P/51/11

From: lilleyarchitecture [REDACTED]
Sent: 16 September 2011 16:09
To: Jonathan Parsons; Katherine Rawlins
Cc: Eve Hearsey
Subject: RE: P/51/11 Extension, alteration and new detached garage 7 Webb Close Pagham
Dear Mr Parsons/Miss Rawlins

From: Jonathan Parsons [REDACTED]
Sent: 14 September 2011 10:10
To: lilleyarchitecture
Cc: Katherine Rawlins; Eve Hearsey
Subject: P/51/11 Extension, alteration and new detached garage 7 Webb Close Pagham

Proposed Site Plan
1:500@A3

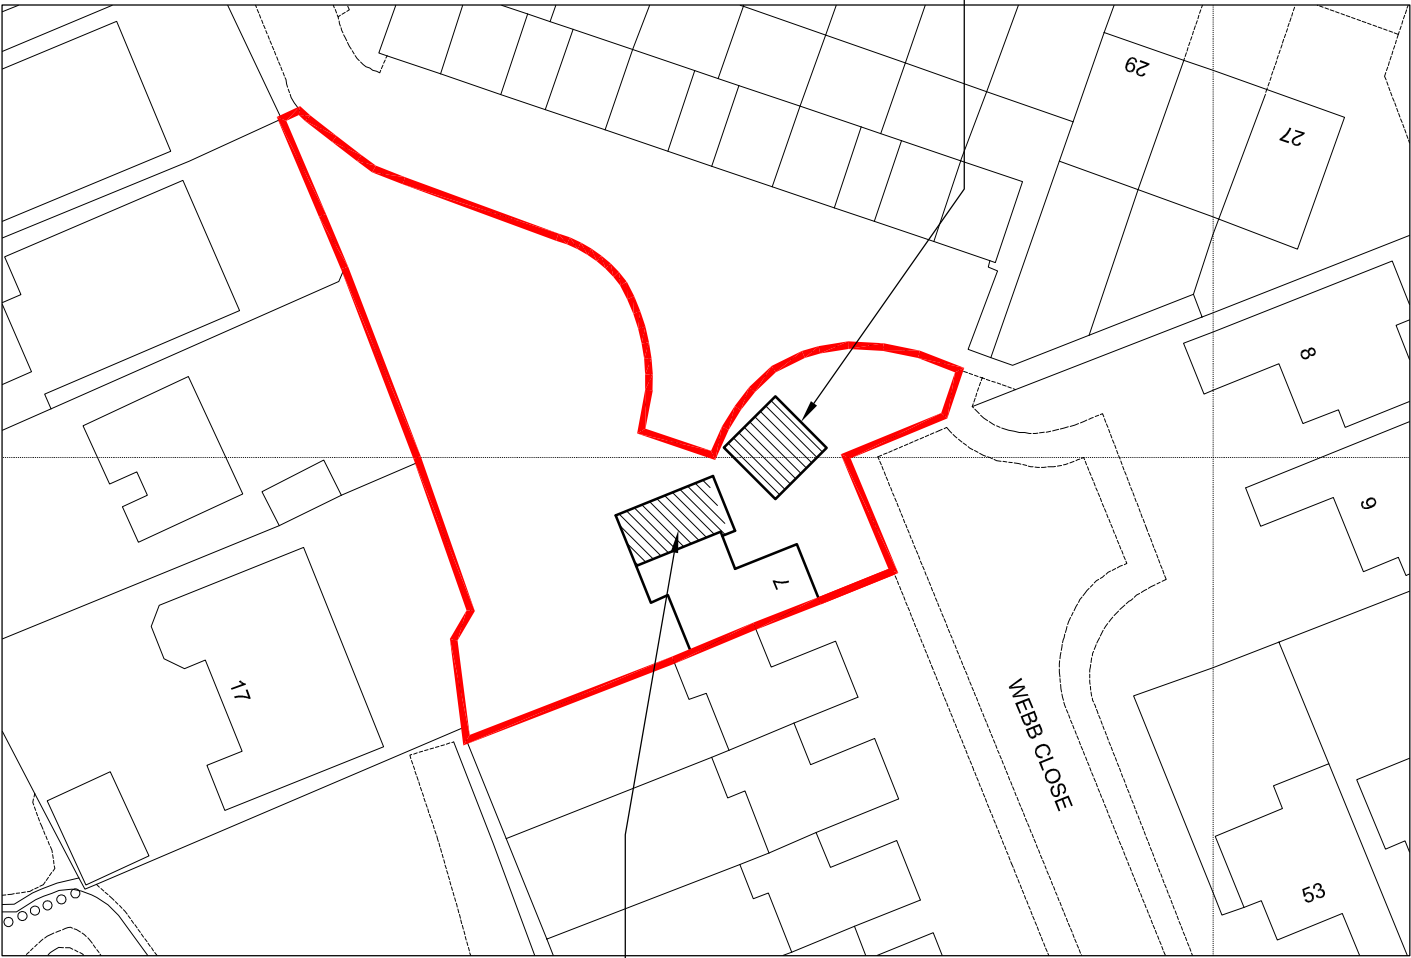
Thank you for your useful comments on revising the application. I take on board your suggestions that regarding the deletion of the garage proposal, addition of the mono pitch roof over the extension and rearrangement of the balcony. I note that you suggest that the balcony will only extend out 1 metre from the rear and a greater distance on the side to the west which overlook your clients garden and a car parking and garage area.

West (side)

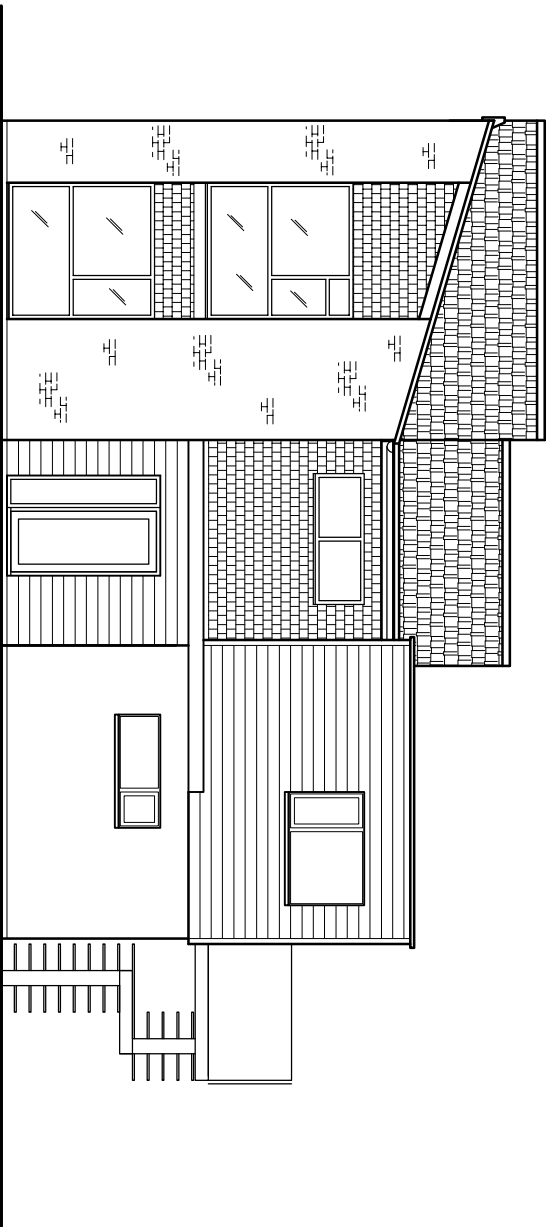
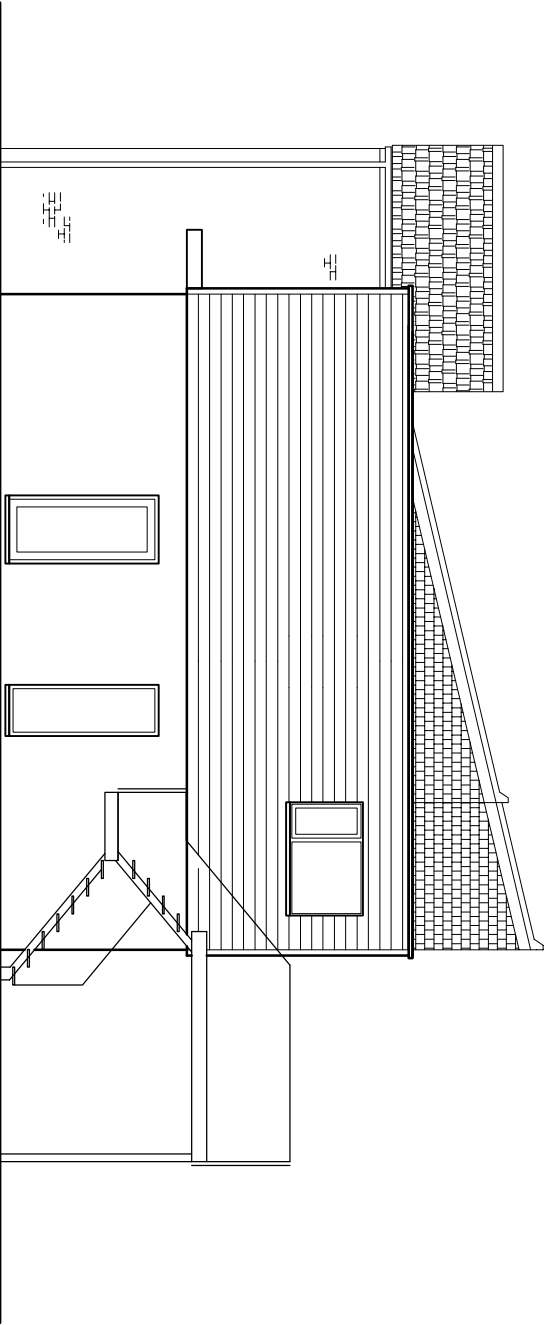
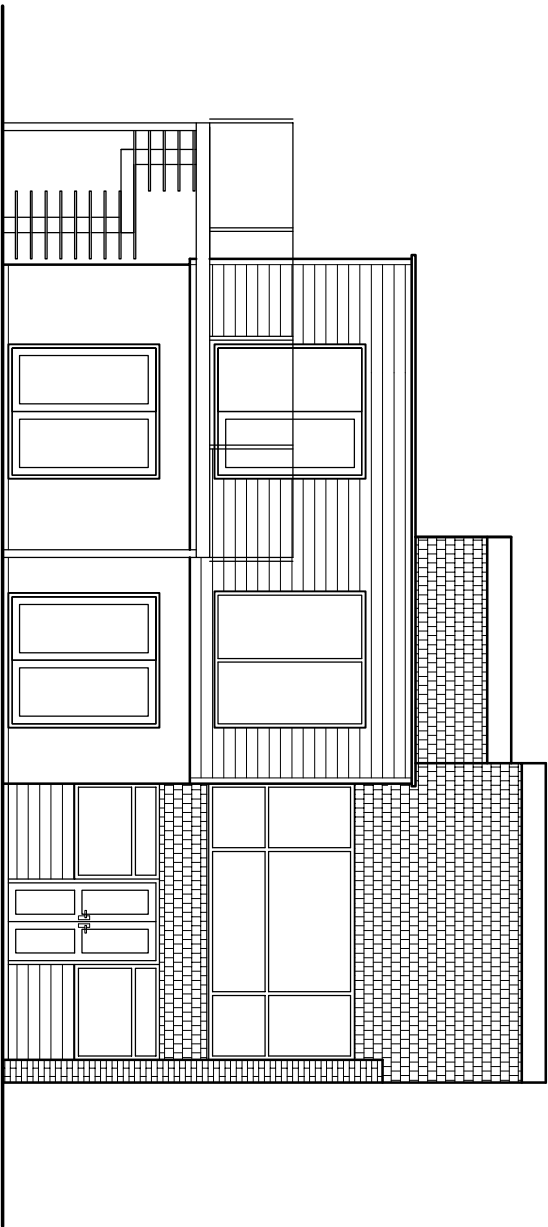
submission which would require new advertising and notification of the Parish Council. In addition officers would still have to consider carefully the impact of any overlooking, even with the reduction in depth on the south elevation, on 17 given the change in levels and the orientation of mono pitch. Should the monopitch have it facing pitch roof sloping down to the western side or should it slope up from the front to the rear or should consist of two roof forms similar to the roof forms on eastern part of the existing building.
